**FINAL DRAINAGE REPORT  
FOR  
LATIGO TRAILS FILING NO. 9  
AND  
ADDENDUM TO MASTER DEVELOPMENT/  
PRELIMINARY DRAINAGE PLAN  
FOR LATIGO TRAILS,  
EL PASO COUNTY, COLORADO**

June 2022

PCD File No.: SF2136

BUFFALO RIVER TRAIL PROFILE
STA 34+00.00 TO 38+00.00

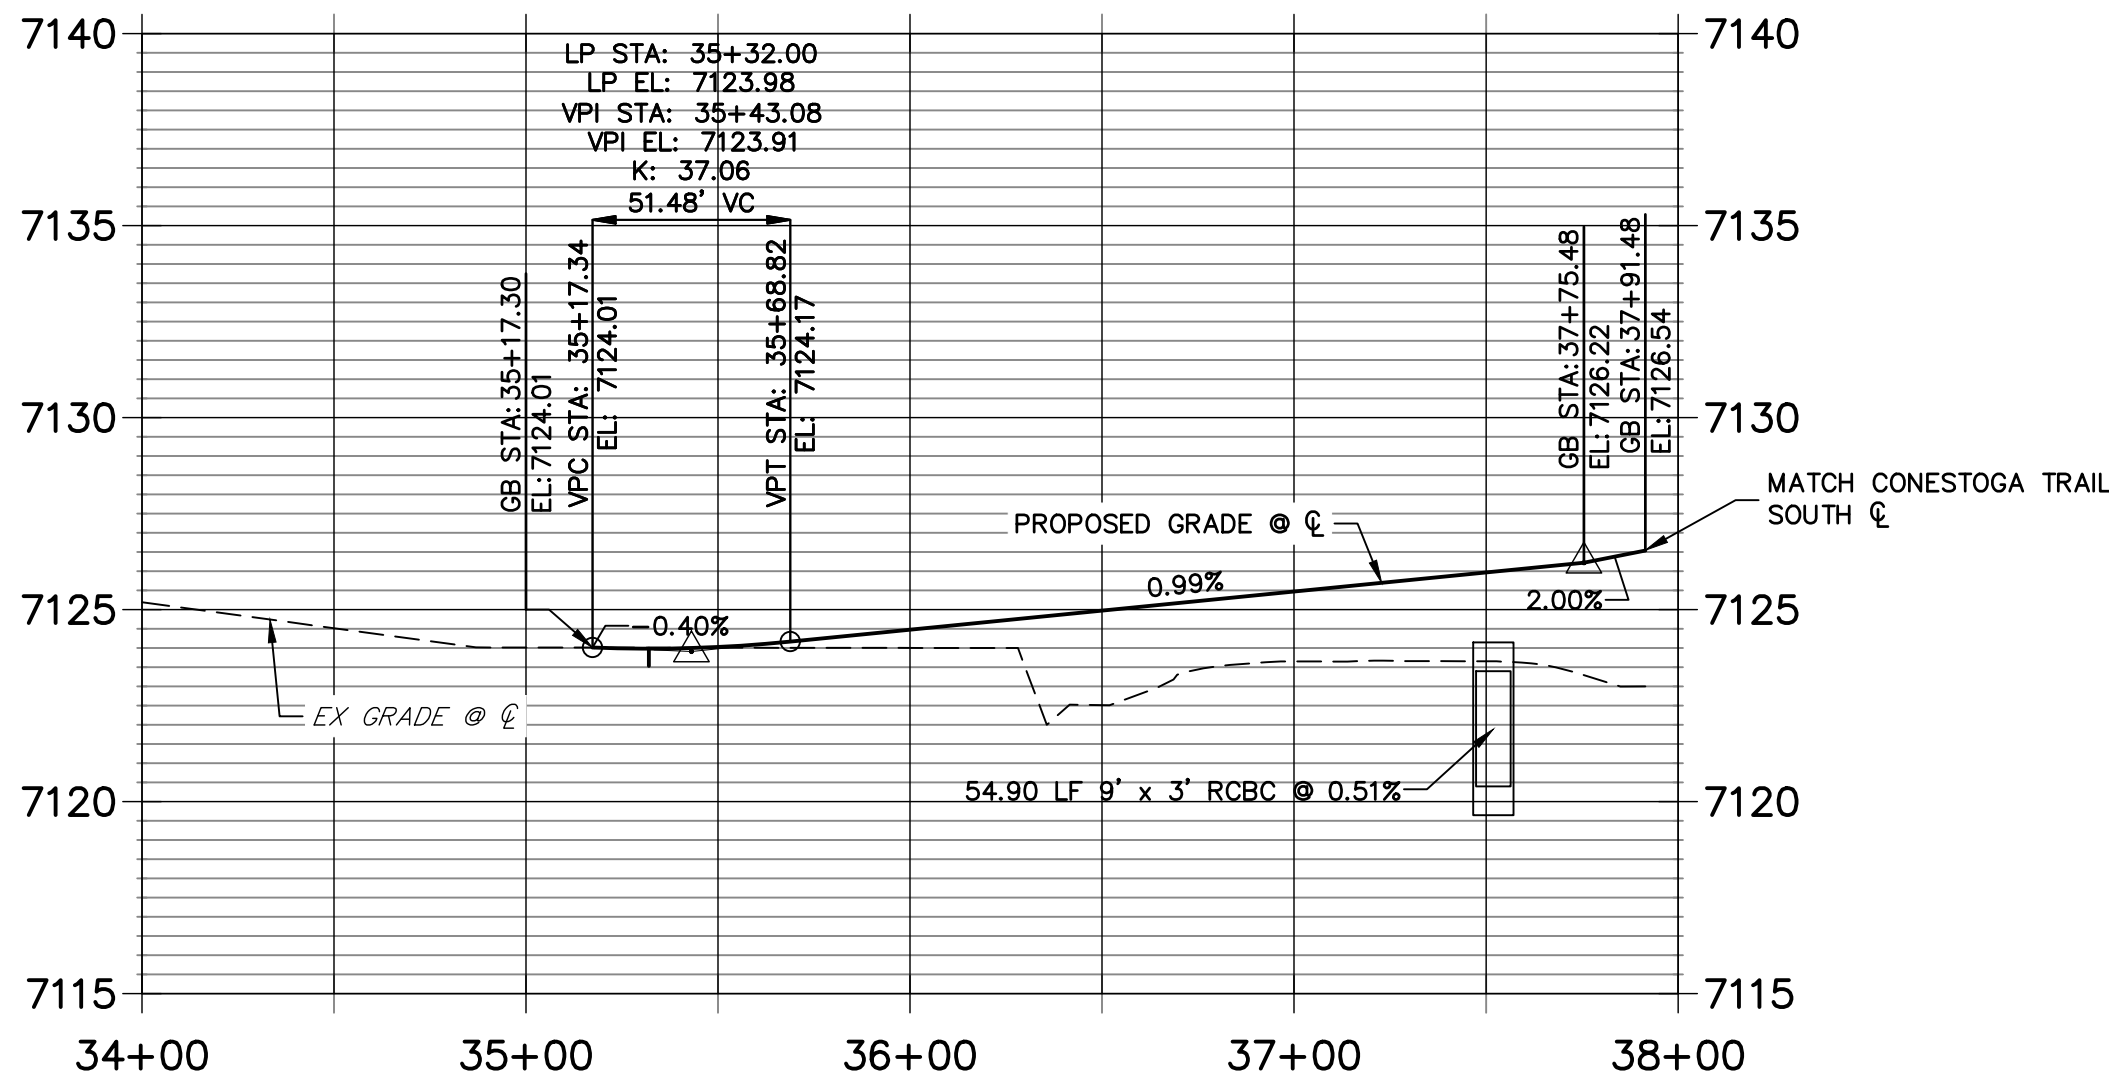
Revise statement. The maximum of 6" over-topping is measured at the shoulder, not the centerline.
